From: Anita Gardner
Sent: 24 July 2019 09:41
To: Planning.Responses
Subject: FW: A/45/19/PL - BMW House, Chandlers Garage, Water Lane
Attachments: Revised red edge.pdf; 17-1030-030 Street Scenes Site Sections Sheet 1 of 2
Revision Sketches For Comment Only (002).pdf

From: Anita Gardner [REDACTED]
Sent: Monday, July 15, 2019 12:10 PM
To: Susan Leeson [REDACTED]
Subject: A/45/19/PL - BMW House, Chandlers Garage, Water Lane

Dear Susan,
I have had a catch up meeting with Neil this morning and we discussed the above application. He has requested street scene elevations to assess the relationship of the apartment building in the north east corner of the site with the neighbouring units in Water Lane and Cumberland Crescent and a street scene of the dwellings facing High

Street Scene Elevation - Facing onto High Street

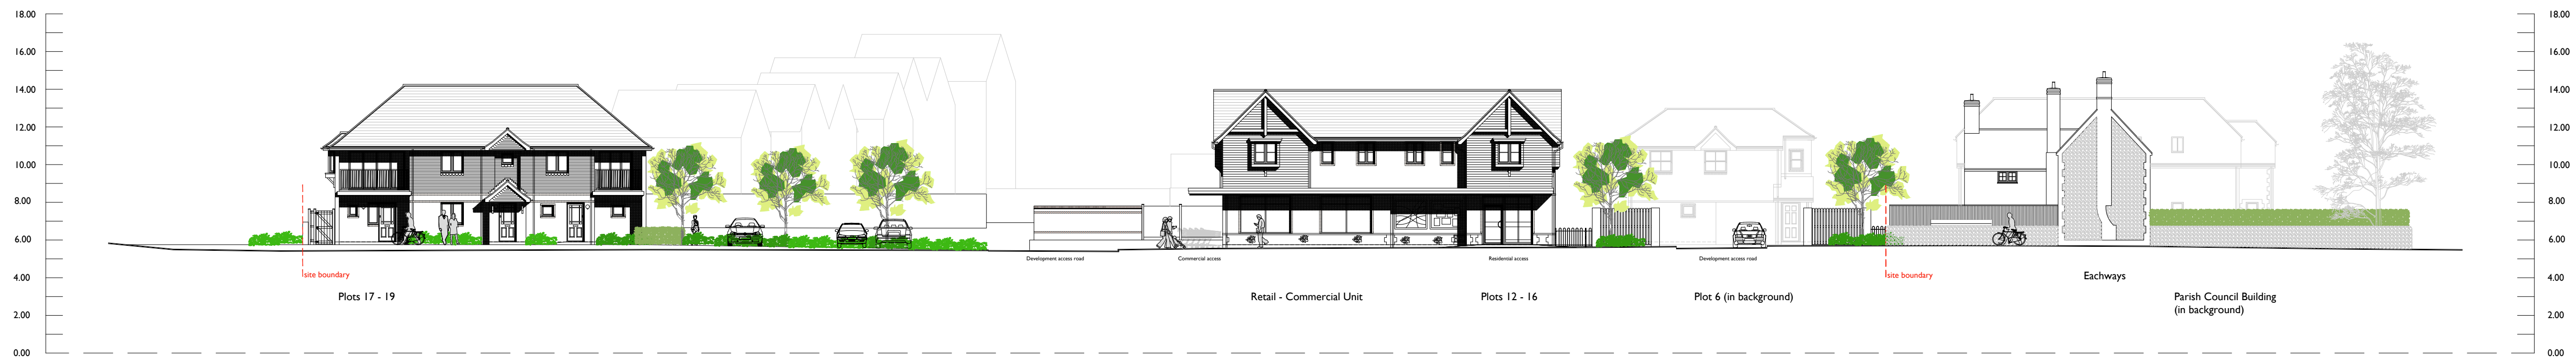
Street with the adjacent properties in High Street. He is concerned that they may appear too low in relation to the neighbouring units.
